## MEMORANDUM

**TO:** Nell Donaldson, Planner  
**FROM:** David Senus, P.E. & Ashley Auger, E.I.T.  
**DATE:** September 2, 2014  
**RE:** Pamela Road Extension, Final Level II Site Plan Application

Woodard & Curran has reviewed the Final Level II Site Plan Application for the proposed extension of Pamela Road in Portland, Maine. The project involves the construction of approximately 750 feet of new road along a paper right-of-way that was established in 1969.

TYPICAL TRENCH SECTION DETAIL
NOT TO SCALE

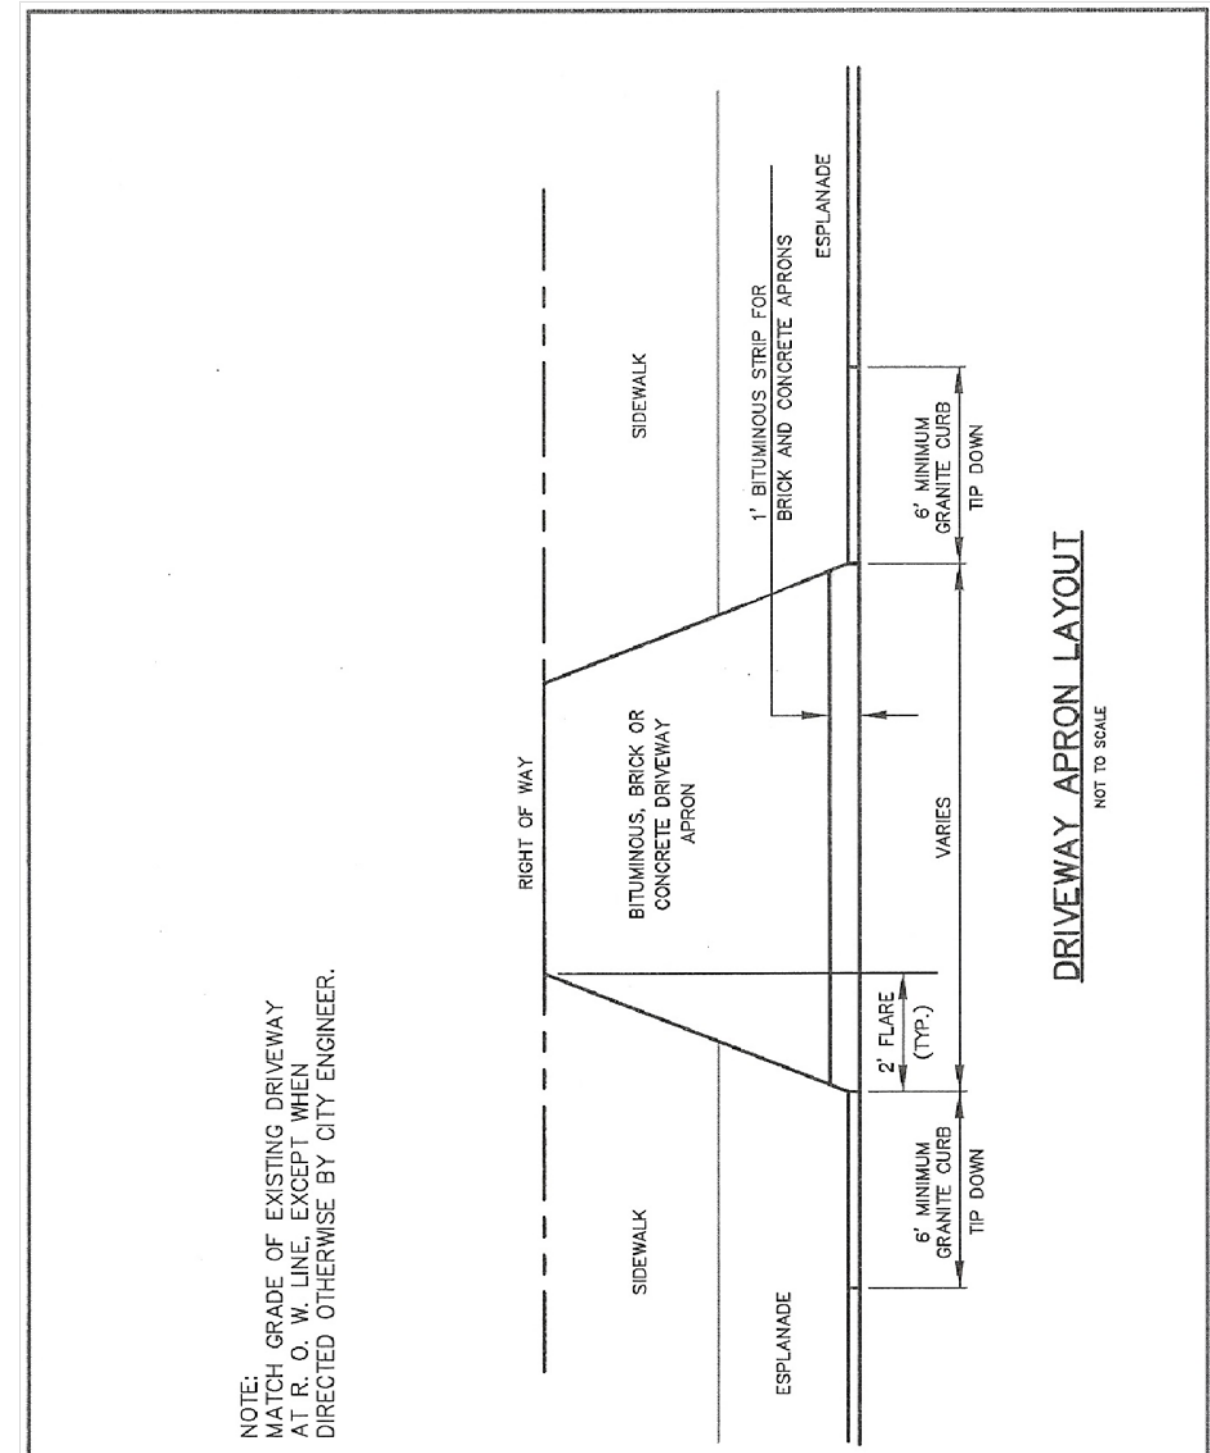
- 9) In accordance with Figure II-12 of the City of Portland Technical Manual,  $\frac{3}{4}$ " crushed stone in typical pipe trench installations shall extend 12-inches above the top of the pipe; the proposed detail specifies six inches. The Applicant should revise accordingly.

Drawing Name:  
**STORMBASIN DETAILS**

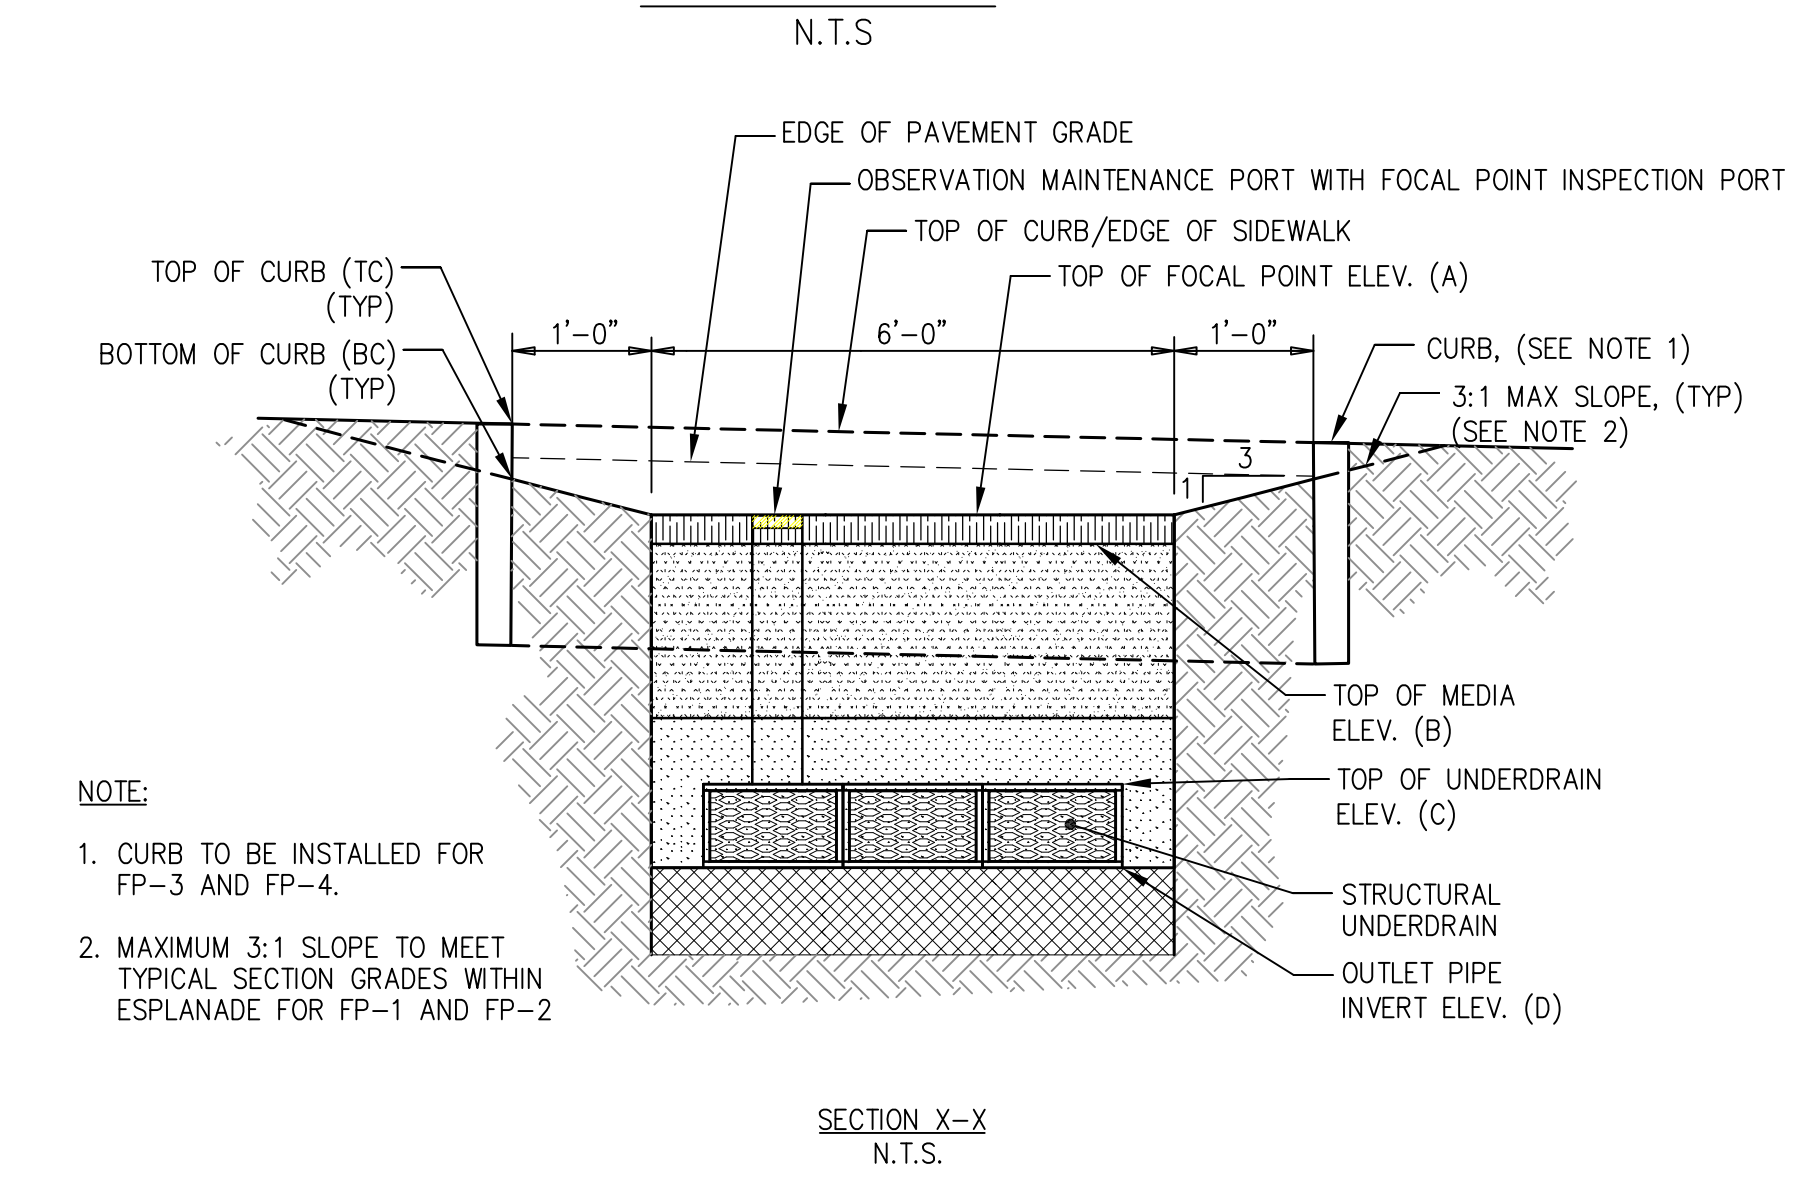
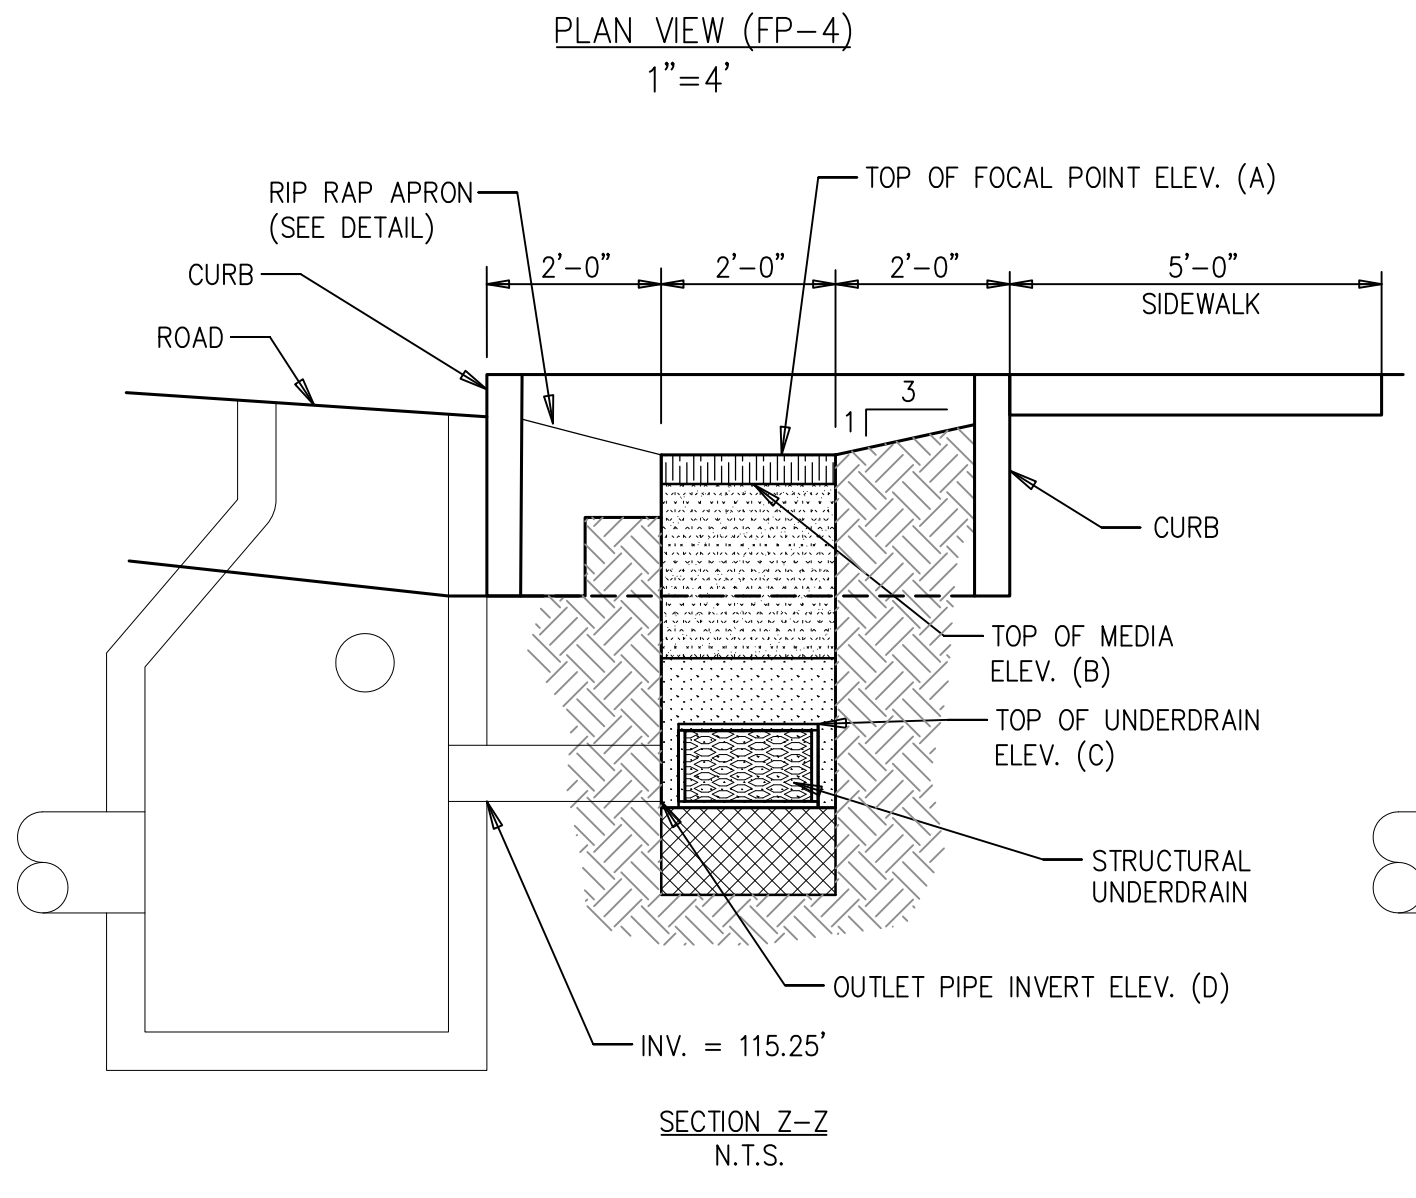
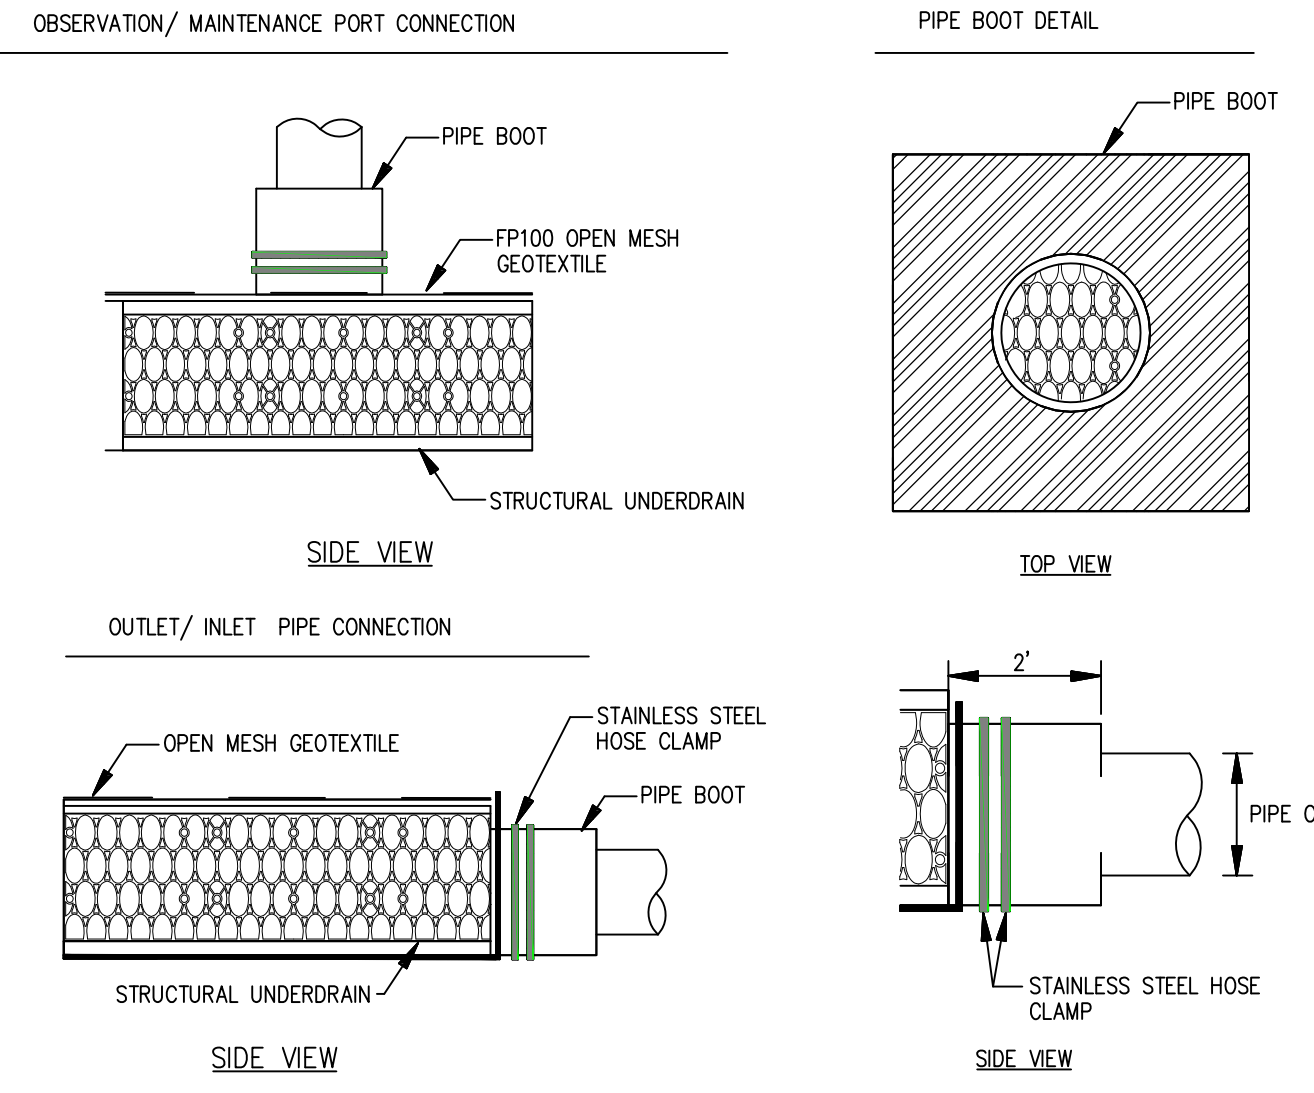
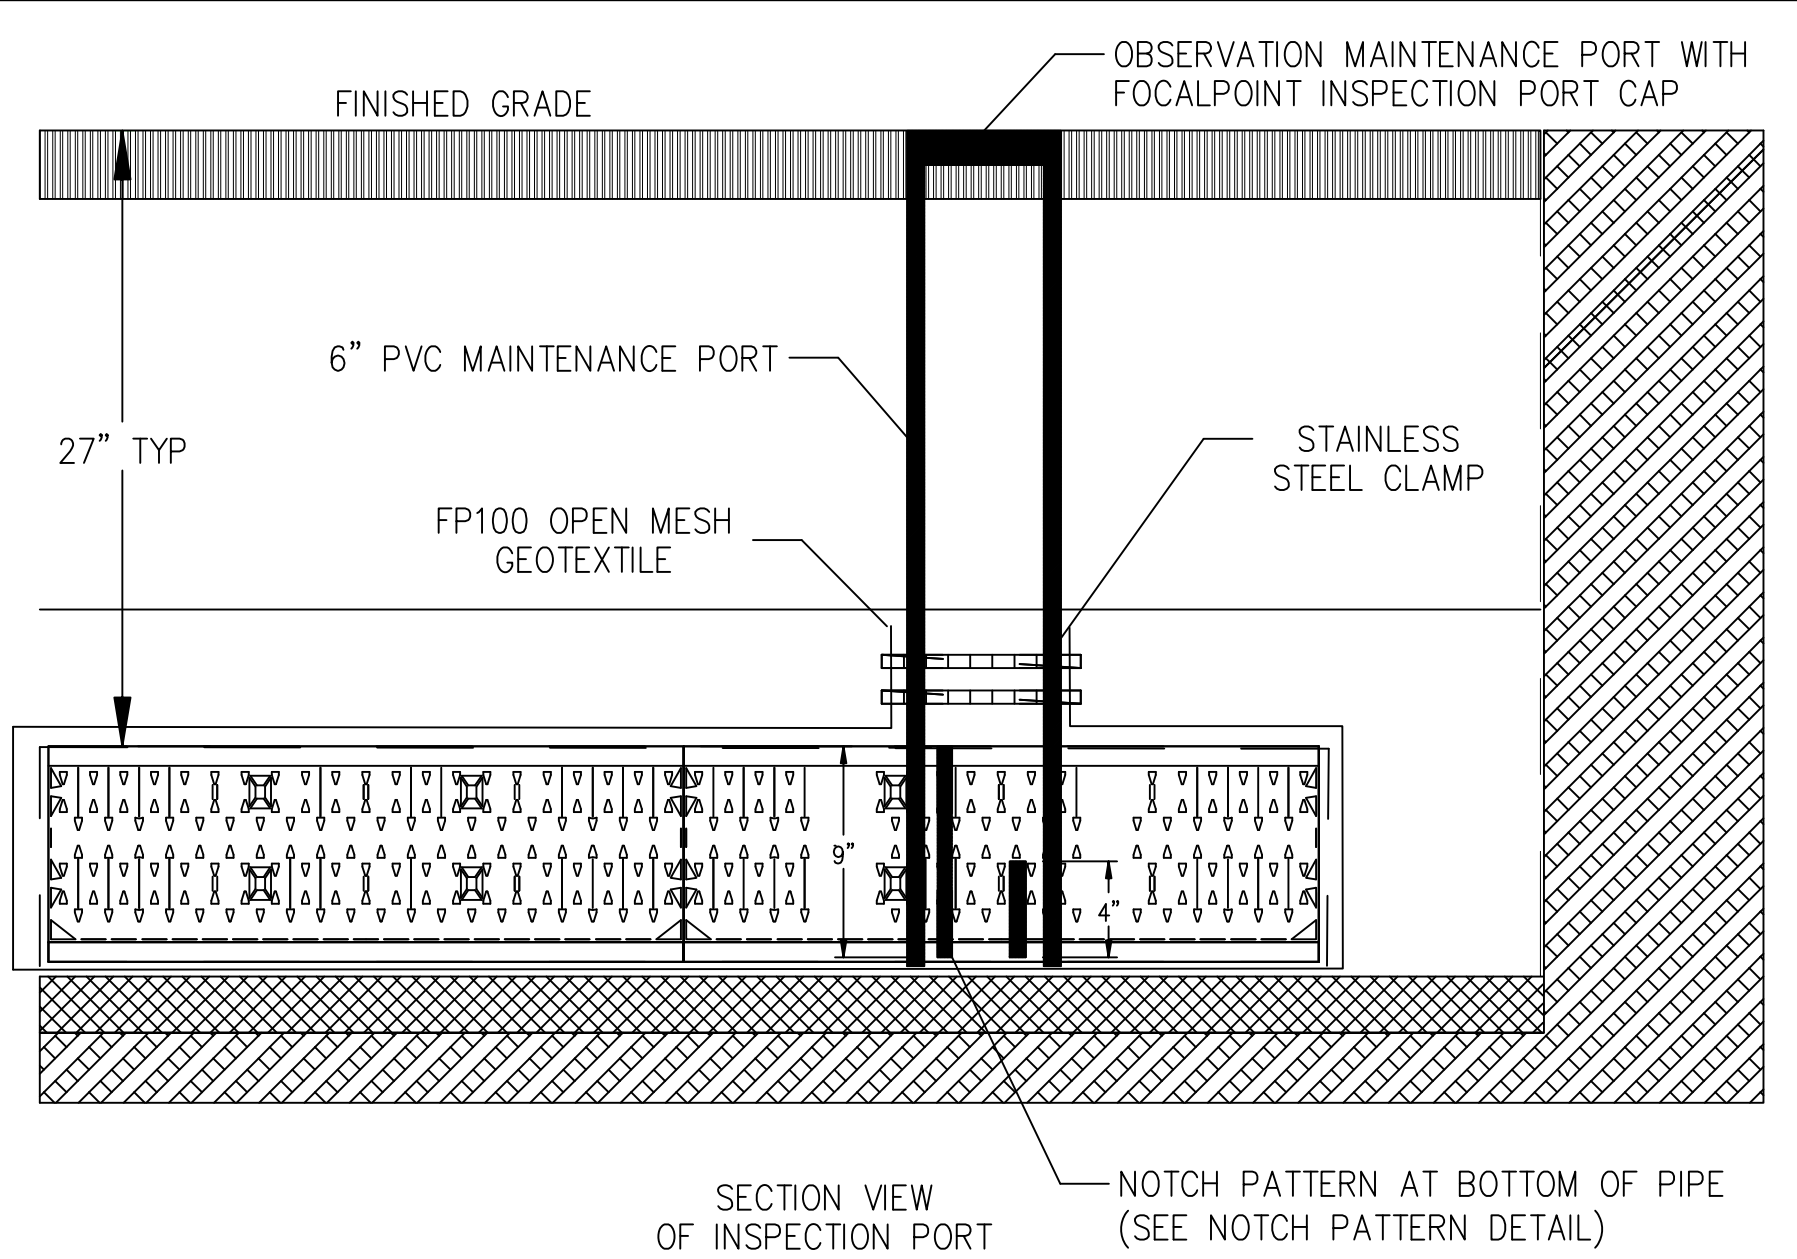
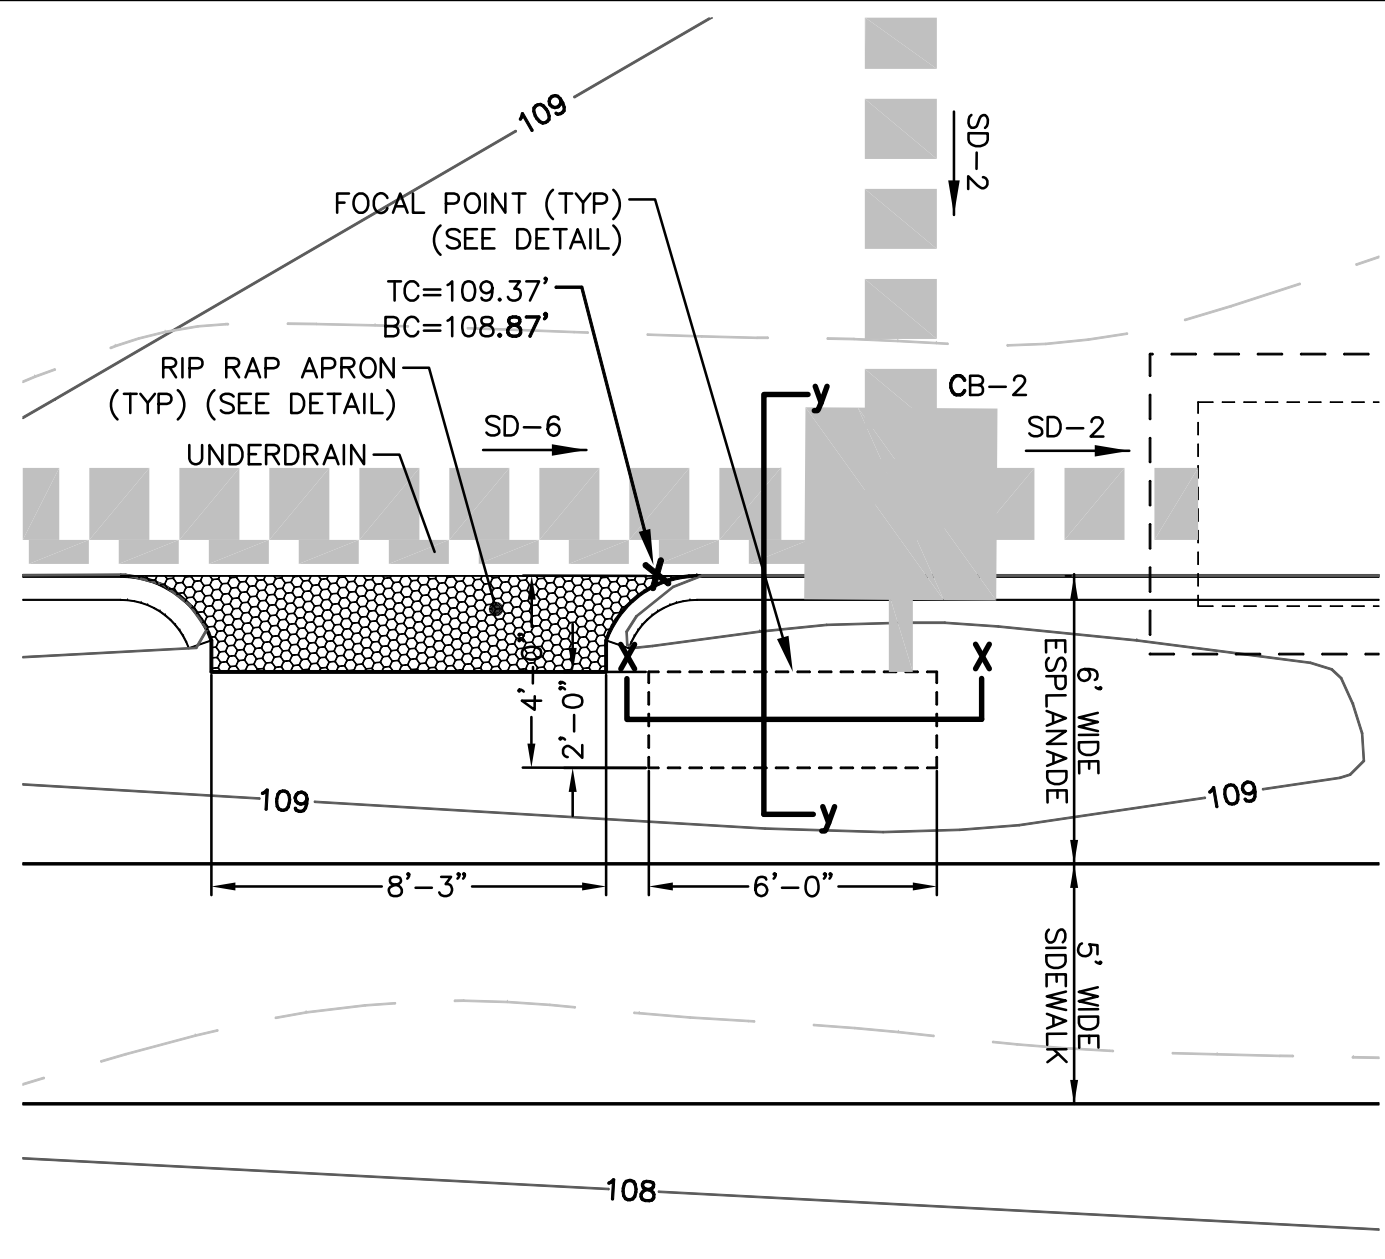
- 7) In accordance with Figure II-2 of the City of Portland Technical Manual, catch basins should have a minimum three foot sump; the proposed detail specifies two feet. The Applicant should revise accordingly.

- 8) The catch basin Frame and Grate detail on Sheet 10 of 11 does not meet City Standard; the City's standard is shown on Figure II-7 of the City of Portland Technical Manual. The detail should be revised accordingly.
